5 November 2014  
Our Ref: 10034 75W Submissions Response.docx

### **Lakes Estate Residential Subdivision – Submission Report**

We refer to your email of 22 August 2014 in relation to the fifteen submissions received during the exhibition of the Section 75W Modification for the above project.

Figure 6: Proposed Subdivision Plan

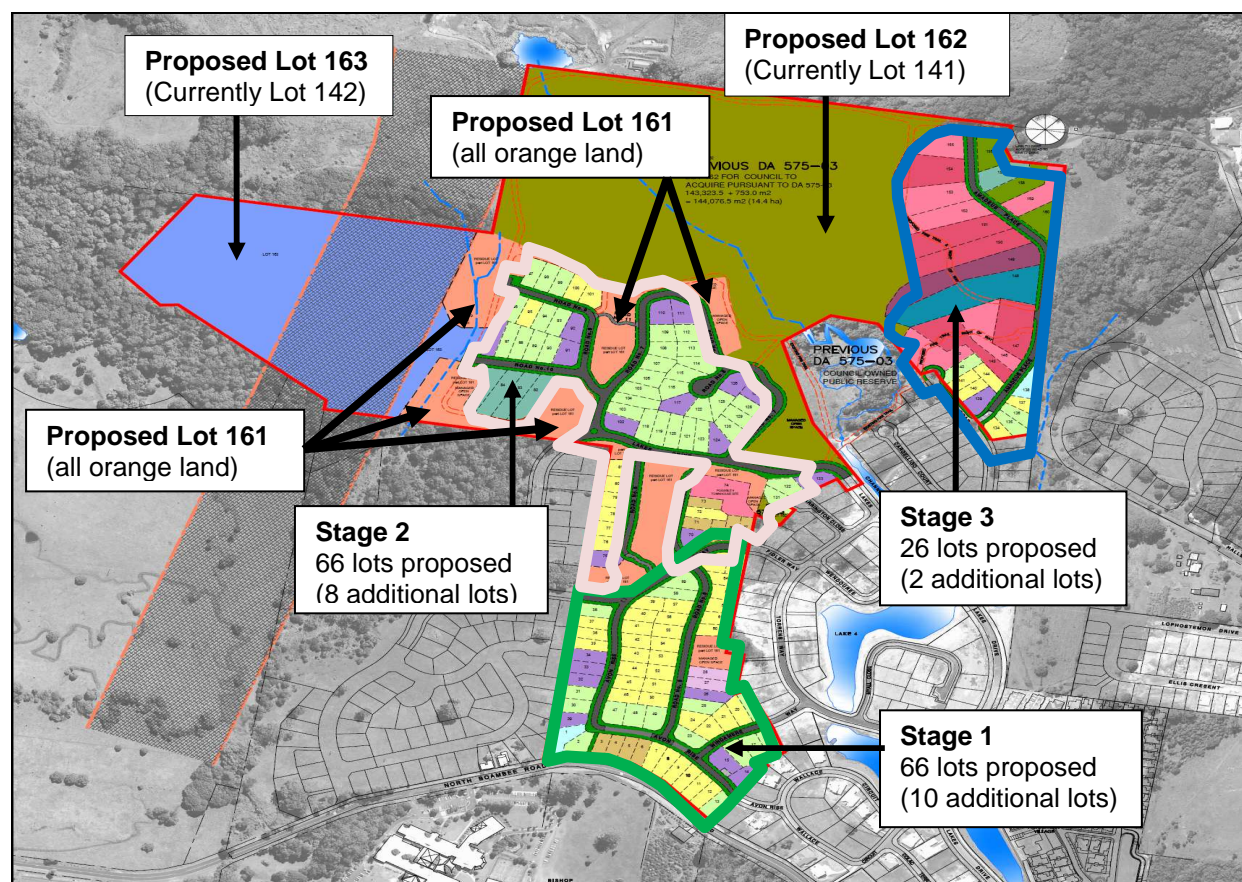
<p><b>2.0 NSW Rural Fire Service Submission</b></p>	
<p><b>2.1 Proposed modification to the subdivision plan:</b></p> <ul style="list-style-type: none"> <li>• Proposed Lot 162 includes land to the east of Stage 2d and south of proposed Lot 131 (stage 2c) that is identified under the currently approved plans for MP05_0129 as 'Reserve managed</li> </ul>	<ul style="list-style-type: none"> <li>• The proposed 75W report does not seek to alter approved bushfire hazard management measures. No modification to conditions E2 to E11 of the Project Approval, which also deal</li> </ul>

*the amended plans have deleted an area of proposed 'managed open space' to the south of Stage 2( d) (i.e. south of proposed Lots 119-123). The applicant is required to demonstrate that adequate asset protection zones are provided for Lots 119-123.*

Submission	Response
<p>as APZ' and 'managed open space'. The Section 75W Modification report does not identify how this land is to be managed and whether there are provisions under DA 575/03 for it management as an asset protection zone as currently approved. The applicant is required to demonstrate that adequate asset protection zones are provided to the east of Stage 2d and south of proposed Lot 131 under the conditions of consent for DA 575/03 for these areas of proposed Lot 162</p> <ul style="list-style-type: none"> <li>• The amended plans have deleted an area of proposed 'managed open space' to the south of Stage 2(d) (i.e. south of proposed Lots 119-123). The applicant is required to demonstrate that adequate asset protection zones are provided for Lots 119-123.</li> <li>• The amended lot layout for Stage 3 results in certain sections of proposed fire trails being located within proposed Lots 143 and 145-155 .The provision for trails over privately owned lots with multiple ownership is contrary to the requirements of section 4.1.3(3) of 'Planning for Bush Fire Protection 2006' and is not supported by the Service .</li> </ul>	<p>comprehensively with bushfire hazard management, are proposed.</p> <ul style="list-style-type: none"> <li>• However, the modified consent will need updating so that the lots numbers in these conditions are changed to reflect the amended plans. These amendments are specified in the submission from the RFS and are agreed to.</li> <li>• The S75W plans (see Dwg A013 Rev G) retains the words "Managed Open Space" across both proposed lots 161 and 162 immediately south of proposed lot 131. If the DPE considers that any uncertainty exists this could be clarified by a further condition of consent.</li> <li>• The S75W plans (see Dwg A013 Rev G) have inadvertently omitted the words "Managed Open Space" from that part of proposed Lot 161 immediately south of proposed lots 119-123. The proponent is committed to provide for the management of this land while required. This could be confirmed by a further condition of consent.</li> <li>• Refer to response to Council comment 1.3.4 regarding fire trails.</li> <li>• These issues are addressed further in the response from Building Code &amp; Bushfire Hazard Solutions (Attachment D).</li> </ul>

I agree with the RFS comments – The areas previously identified as managed open space must be managed to a state that is not conducive to bushfires. It is requested that this be conditioned as part of the RFS approval.

SUBDIVISION STAGE 1 PLAN_Response TO RFS LOTS 1-58 AND PART LOT 141 (RESIDUAL)

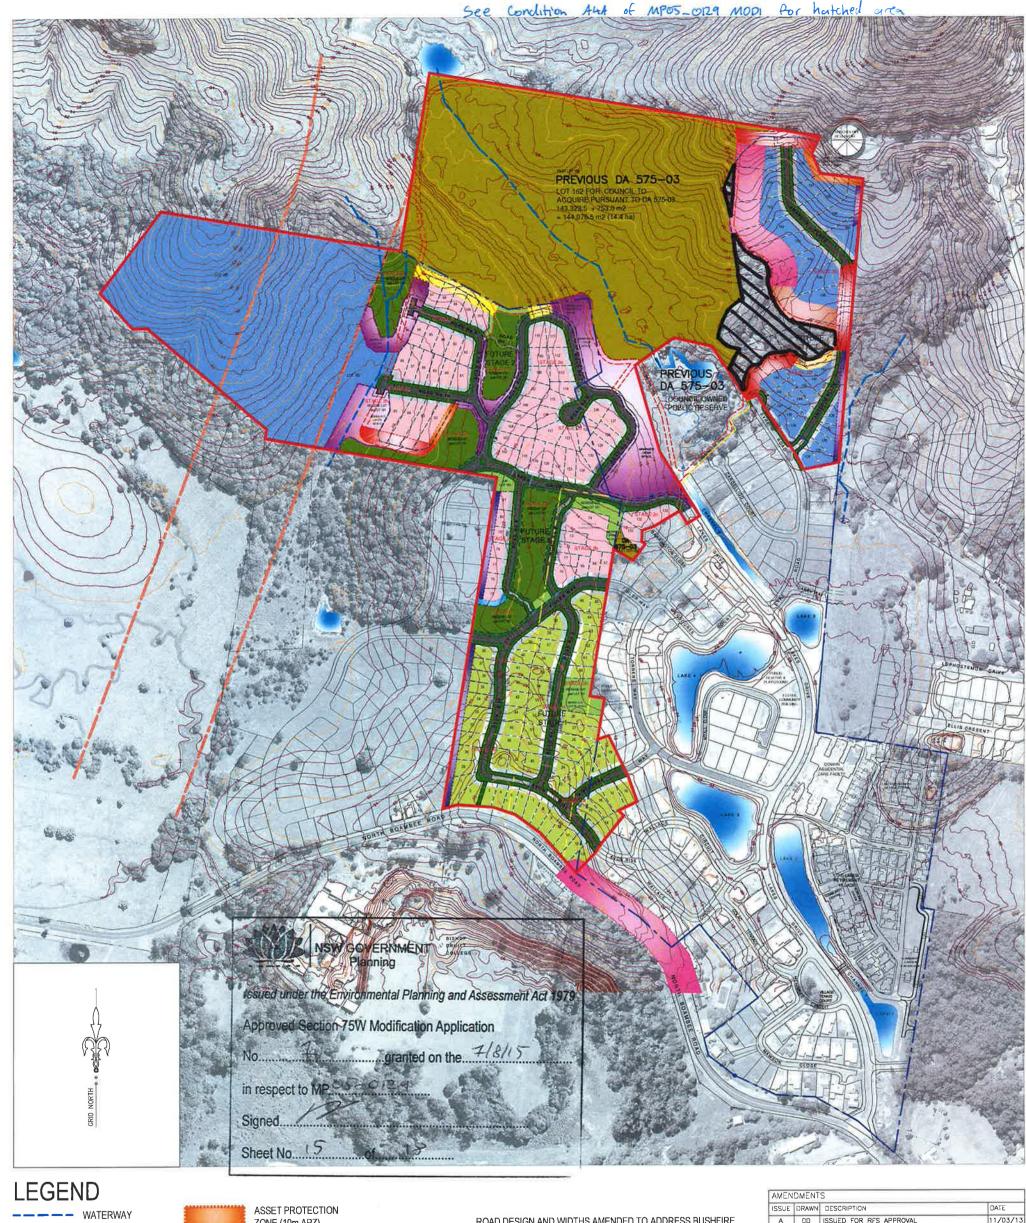
- i) APZ over southern portion of Lot 75 to increase to 9 metres;*
- ii) APZ over southern portion of Lots 82, 83, 84 and 85 be increased to 21 metres;*
- iii) include a 10 metre wide APZ along the eastern boundary of Lot 101 - measured from the western edge of the unmanaged vegetation;*
- iv) include a 10 metre wide APZ over Lot 163 along the western edge of Lot 86;*
- v) APZ over the eastern portion of Lots 137 and 138 being increased to taper from 9 metres wide at the south to 12 metres wide at the north;*
- vi) APZ to the north-west of Lots 143, 145 and 146 being increased to 21 metres; and*
- vii) APZ over the northern portion of Lot 147 being increased to 13.5 metres.*

*It is also noted that the modified subdivision plans do not include the above asset protection zone requirements. The Services recommends that these amendments be shown on the modified subdivision plans to correctly reflect the approval conditions and to avoid potential confusion due to the discrepancy between the approved plans and approval conditions.*

Point 3 & 4 made are corrections so the consent is consistent with the new plans (i.e. making sure the conditions reference the correct new lot numbers). I have reviewed these comments and they are consistent with the original approval.
